# KIRKLEES METROPOLITAN COUNCIL INVESTMENT & REGENERATION SERVICE

### DELEGATED DECISION TO DETERMINE PLANNING APPLICATION FOR ADVERTISEMENT CONSENT

Reference No:	<b>2024/64/92029/W</b>
Site Address:	Alice In Groomingland, 7, Beast Market, Huddersfield, HD1 1QF
Description:	Erection of illuminated and non-illuminated signs (Listed Building within a Conservation Area)
Recommending Officer:	Lucy Taylor

KBS SIGNS  
ARTWORK APPROVAL

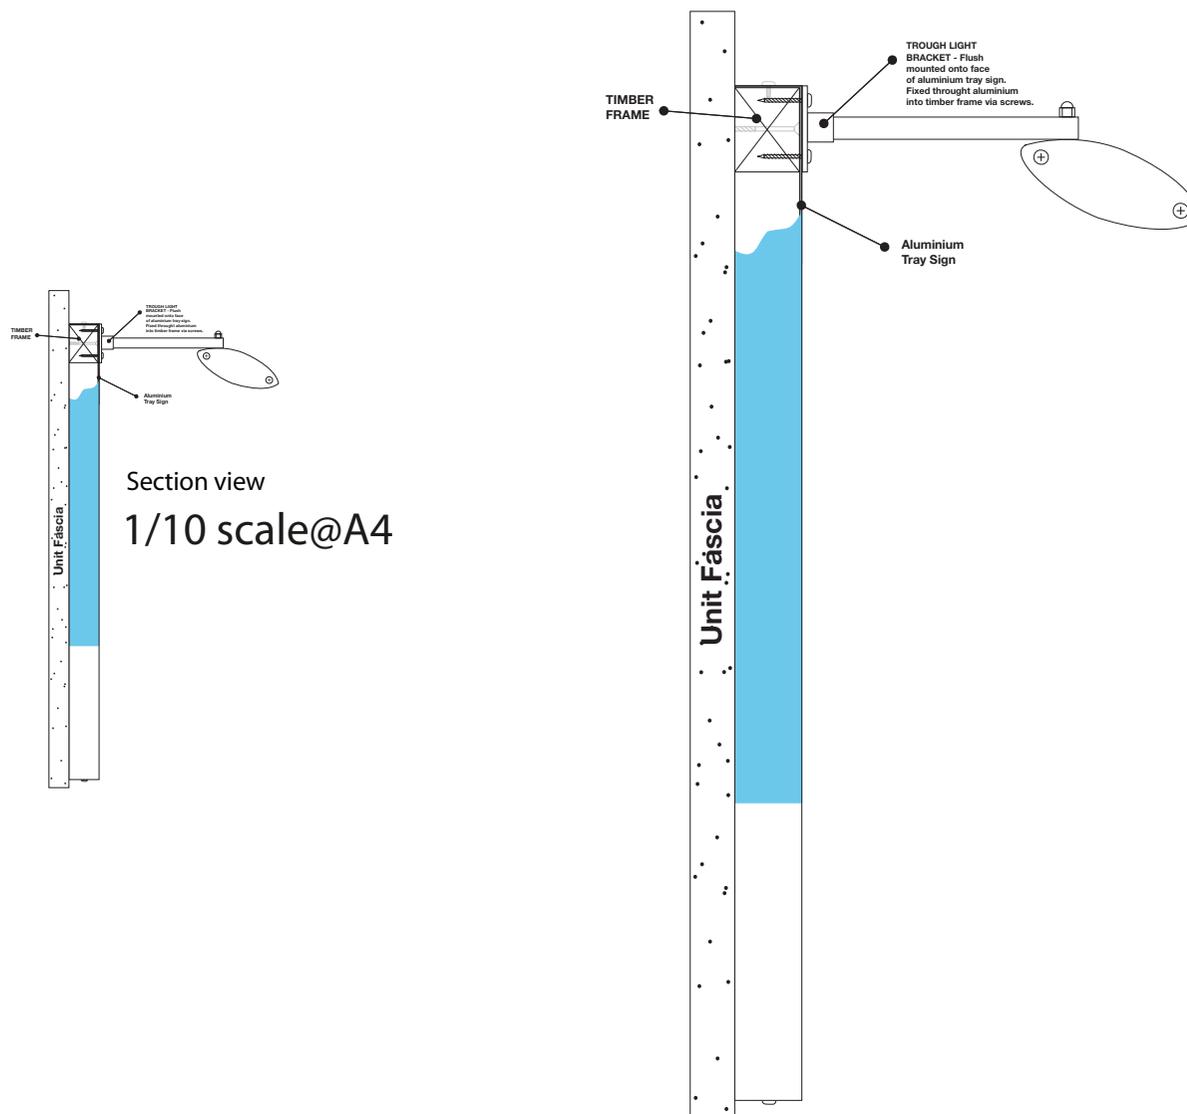
It is recognised that the previous occupants of the building did have a small window vinyl in place to the left-hand side and right-hand side, however, the proposals under this Advertisement Consent application will see the entire window frontage covered in vinyl/details. It is considered that this amount of detailing would result in the main windows appears as overly cluttered, in turn, failing to preserve or enhance the character of the building.

Turning to the proposed signage on the fascia, the previous sign appears to be projecting metal lettering on a timber fascia board, with these proposals for a composite aluminium board with vinyl lettering. It is considered that the proposed signage should reflect the design and style of the previous signage and should have a timber backing board (make use of the existing fascia

board) and the lettering should be projecting lettering or could equally be painted directly onto the fascia board.

With regard to the proposed lighting, this is considered to further cause harm with regard to the impact of the proposed fascia signage, adding a negative detail. It is considered that lighting should be omitted from the scheme.

1. The proposed advertisements, by virtue of their siting, materials, scale, design and nature of illumination, would create an overly cluttered frontage as a result of the extent of vinyl proposed to the glazing and an see the introduction of a fascia sign that would have an incongruous appearance that fails to reflect the design and style of the building and wider locality with the artificial lighting of this sign leading to additional visual harm. The advertisements would have a harmful impact upon the visual amenities and heritage significance of the site and local area, crating strident and discordant features. To permit such development would be contrary to Policies LP24, LP25 and LP35 of the Kirklees Local Plan, policies within Chapters 12 and 16 of the National Planning Policy Framework and the requirements of section 16(2) of the Planning (Listed Building and Conservation Area) Act.
